Recommendation Report for Planning Permission for Works or Extension to a Dwelling

REF NO: A/102/17/HH

LOCATION: 2 Meadowside
Angmering

PROPOSAL: Retention of 1.83m high timber fence to north boundary. Install new 1.83m high timber fence with laurel planting to south facing boundary, reducing to 1m high forward of house. Re-Submission following A/96/16/HH.

Elevation of new boundary treatment
Scale 1:100 @ A3

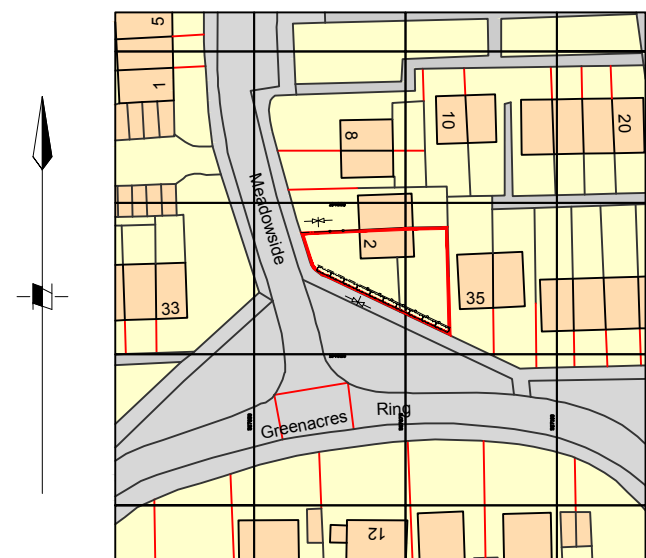
The proposed fence will be located in a prominent position on the corner of Meadowside and Greenacres Ring which is a large open corner. Both 33 Greenacres and 2 Meadowside occupy prominent corner plots and have a shared harmonious open character. The design of these properties and their siting creates a symmetry to the junction. The loss of this green hedge (which is not subject to planning control) and its replacement by a solid timber fence has the effect of unacceptably harming visual amenity. Even though it is now proposed to set the fencing back 1m from the site boundary and planting is proposed in front this would take time to establish and the fencing would still be readily visible in the street scene and appear as an obtrusive and discordant feature.

The proposed fence by virtue of its design, location and size is considered to have an unacceptably adverse impact upon the established character of the street scene contrary to policy GEN7(ii) of the Arun District Local Plan and policy HD5 of the Angmering Neighbourhood Plan.

- 1 The proposed fencing to the southern boundary by virtue of its location, height, siting, colour and materials would appear as an incongruous feature and would have an unacceptable prejudicial impact on the character and appearance of the area in conflict with policy GEN7(ii) of the Arun District Local Plan, policy HD5 of the Angmering Neighbourhood Plan and the National Planning Policy Framework.
